EPC STORMWATER REVIEW COMMENTS ARE SHOWN IN ORANGE BOXES WITH BLACK TEXT

2022 Financial Assurance Estimate Form
(with pre-plat construction)

PROJECT INFORMATION		
Peaceful Ridge at Fountain Valley Sub	5/23/2022	EGP-213
Project Name	Date	PCD File No.

* Refer to design details: Allan Block typical reinforced wall application for all other notes, details and specifications.

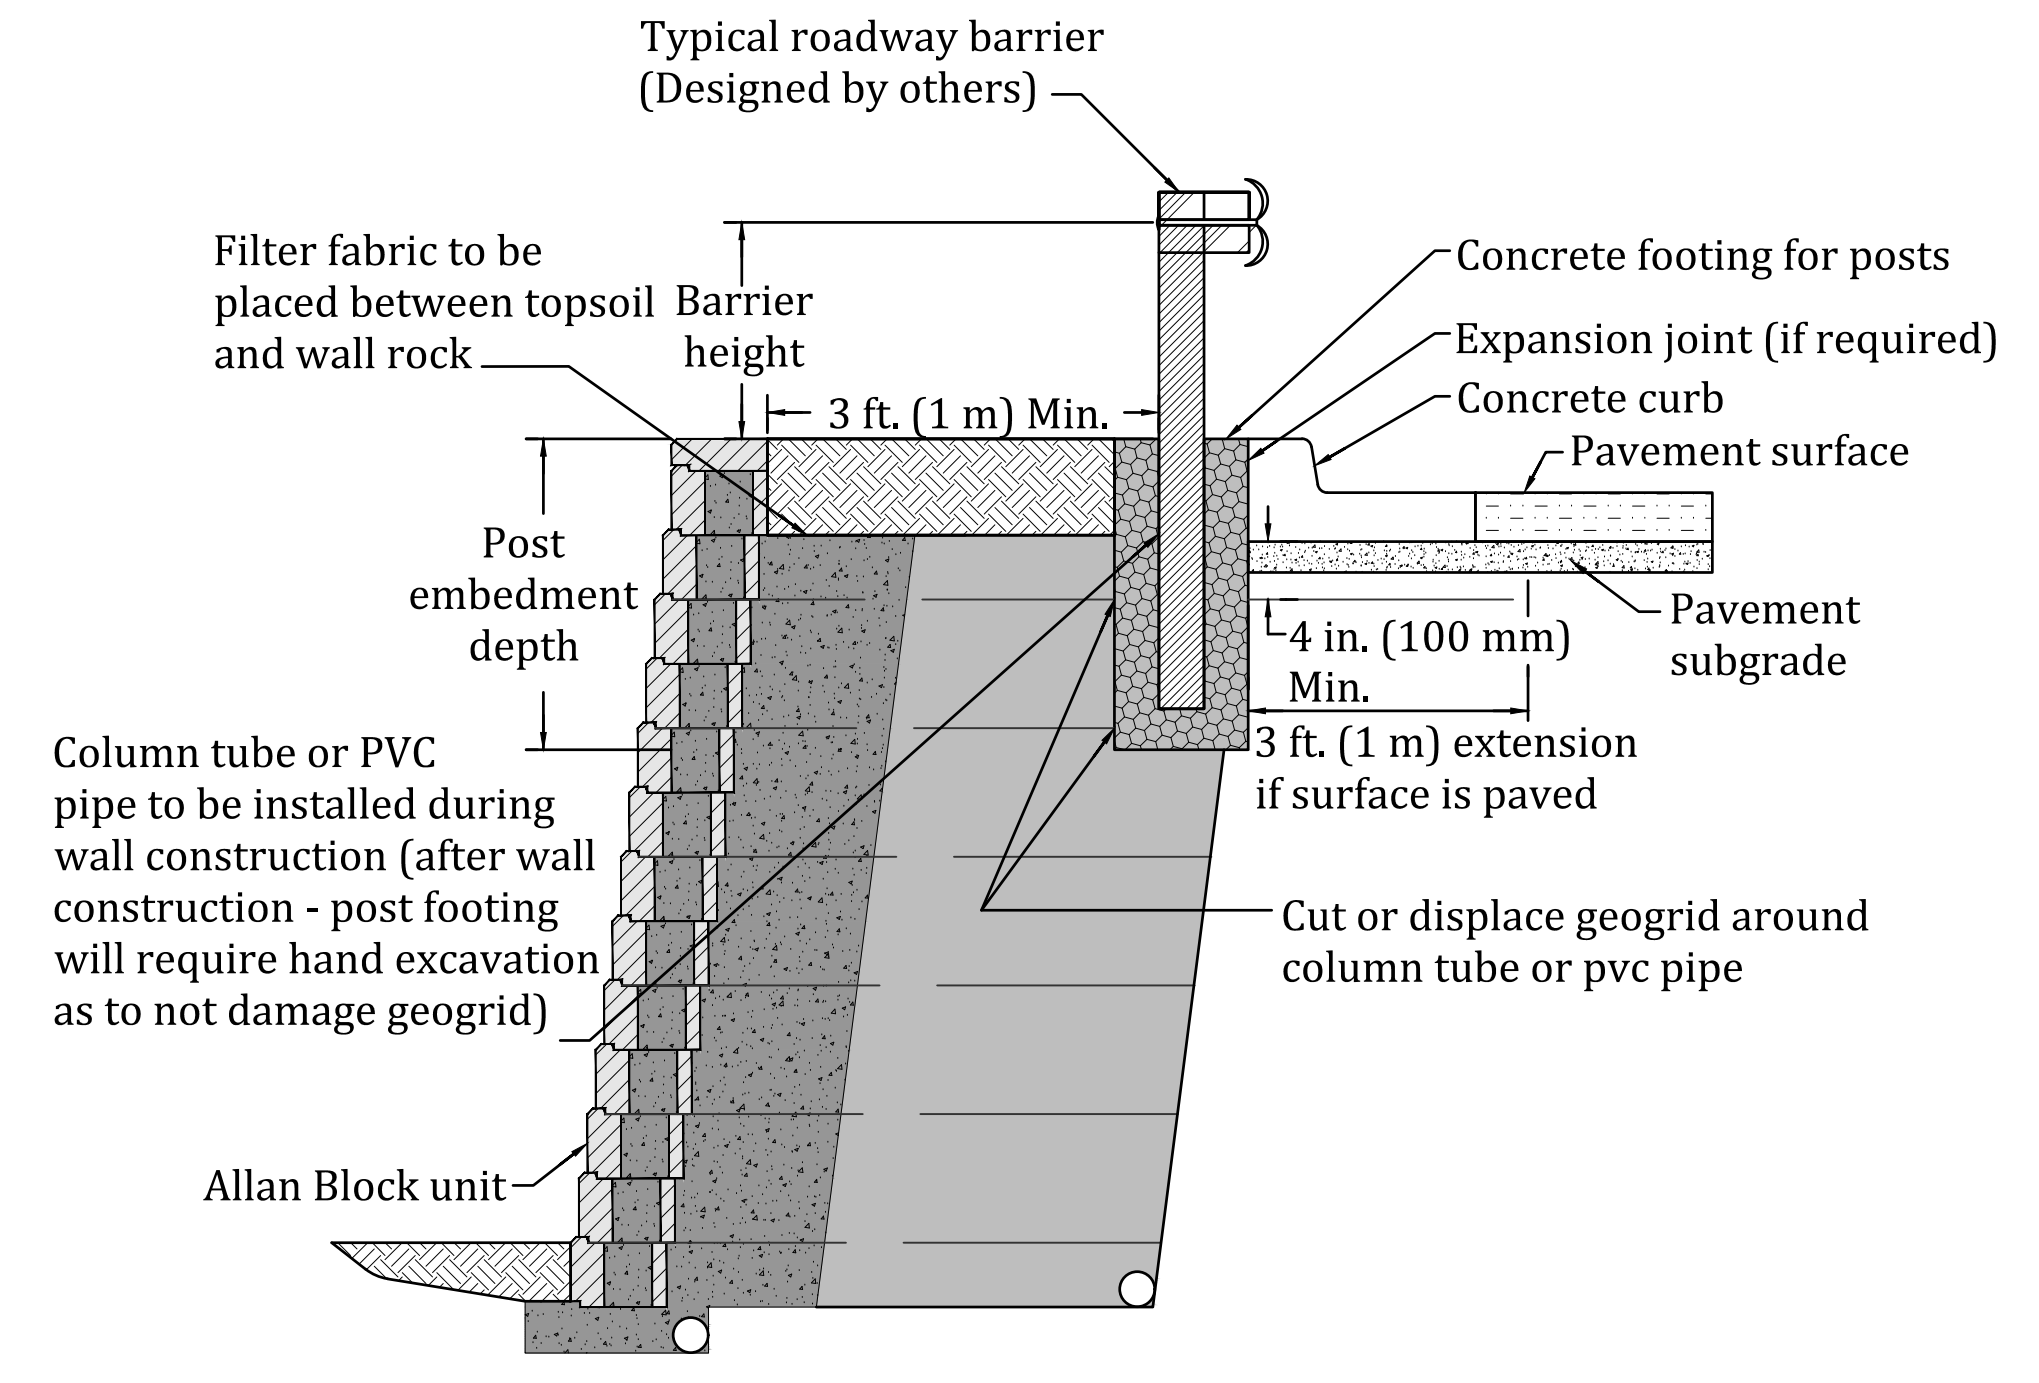
Include retaining walls at/near pond
